Consultation Response from: KC Environmental Health (Pollution & Noise Control)
2023/90772 Land at, Penistone Road, Fenay Bridge, Huddersfield, HD8 0AW
Discharge conditions 3 (CEMP), 7 (waste collection), 14 (soft landscape), 17 (boundary treatment), 25 (tree/shrub planting) on previous permission 2020/90725 for erection of 68 dwellings with associated access, parking and open space (revised plans)
Responding Date:
23rd March 2023

Responding Ref:
WK202307584

Drawing Title	
Construction Management Plan	
Site	
Penistone Road, Fenay Bridge	
Scale @ A1	Date
1:500	06.03.23
Drawn	Checked
BH	.
Drawing No.	Rev.
FB-006	B

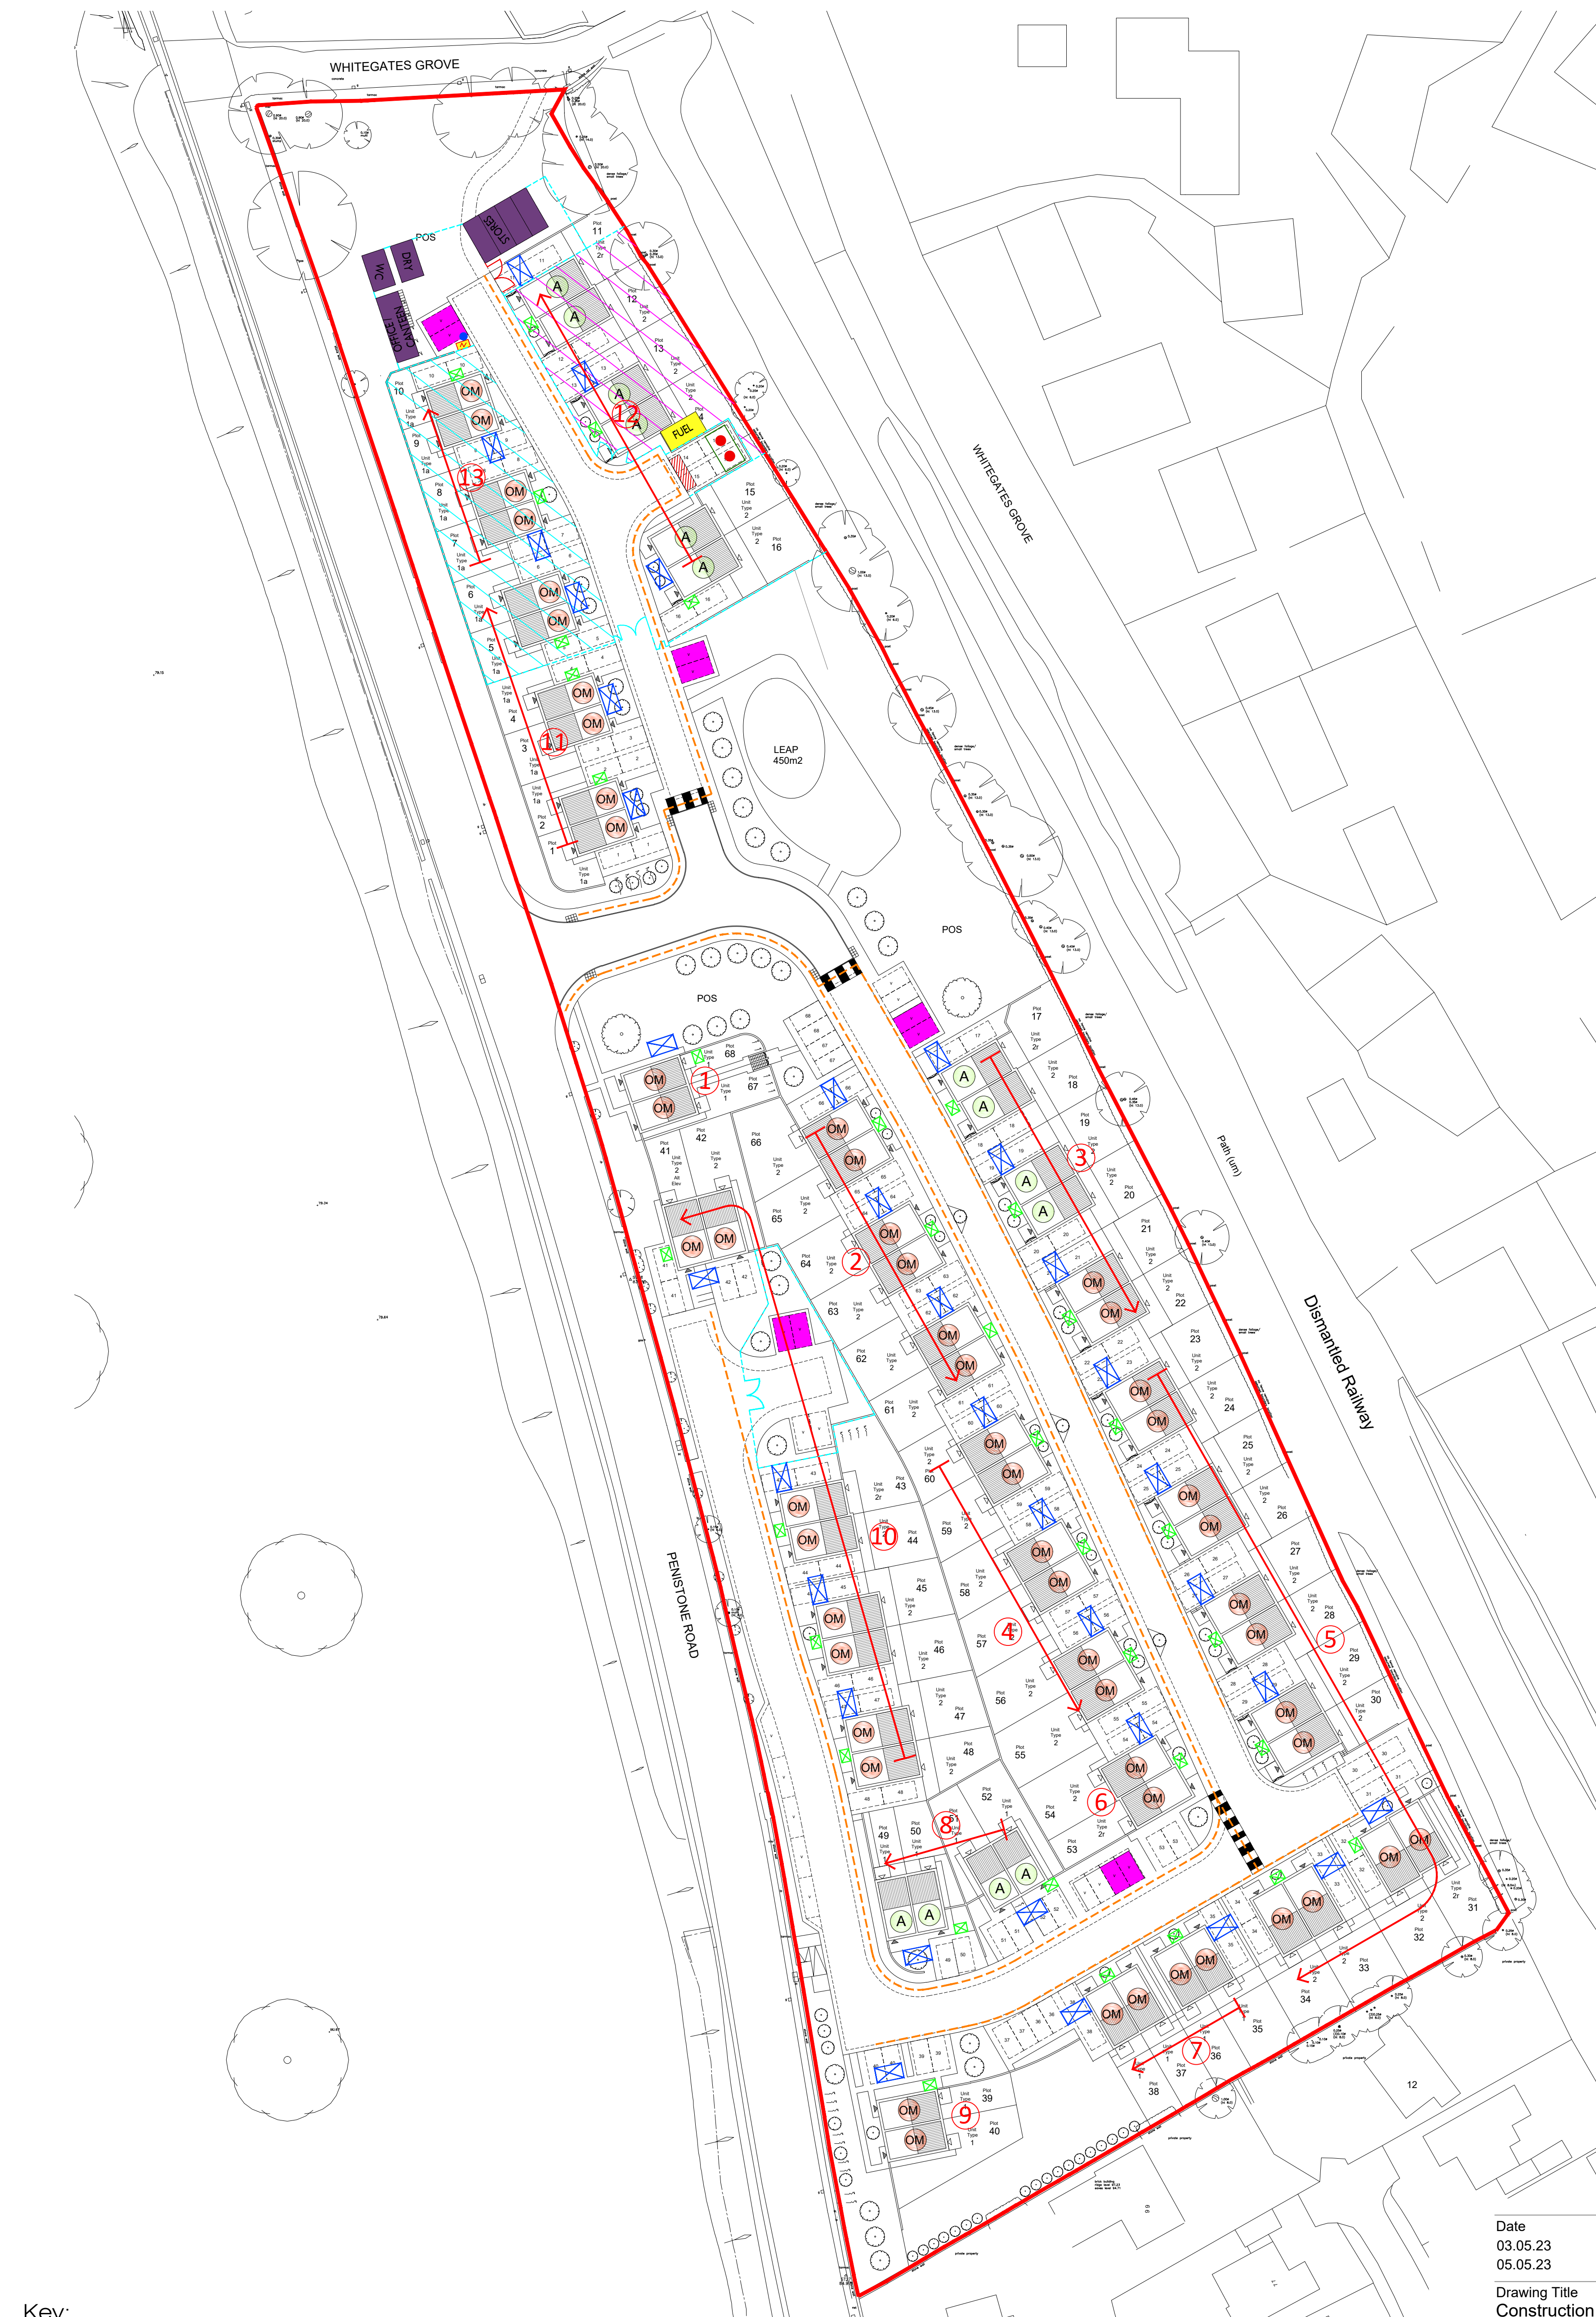
We have reviewed application 2023/90772 and make the following comments and recommendations. To assist with the discharge of condition 3 – Construction Environmental Management Plan the applicant has submitted a plan titled Construction management plan, dated 06.03.23, reference FB-006. This does not constitute a Construction Environmental Management plan as it only satisfies point - d) of condition 3.

We do not accept the information provided and recommend condition 3 remain in place.

We would advise the applicant to provide the site specific information required by the condition and guidance can be found in the following documents.
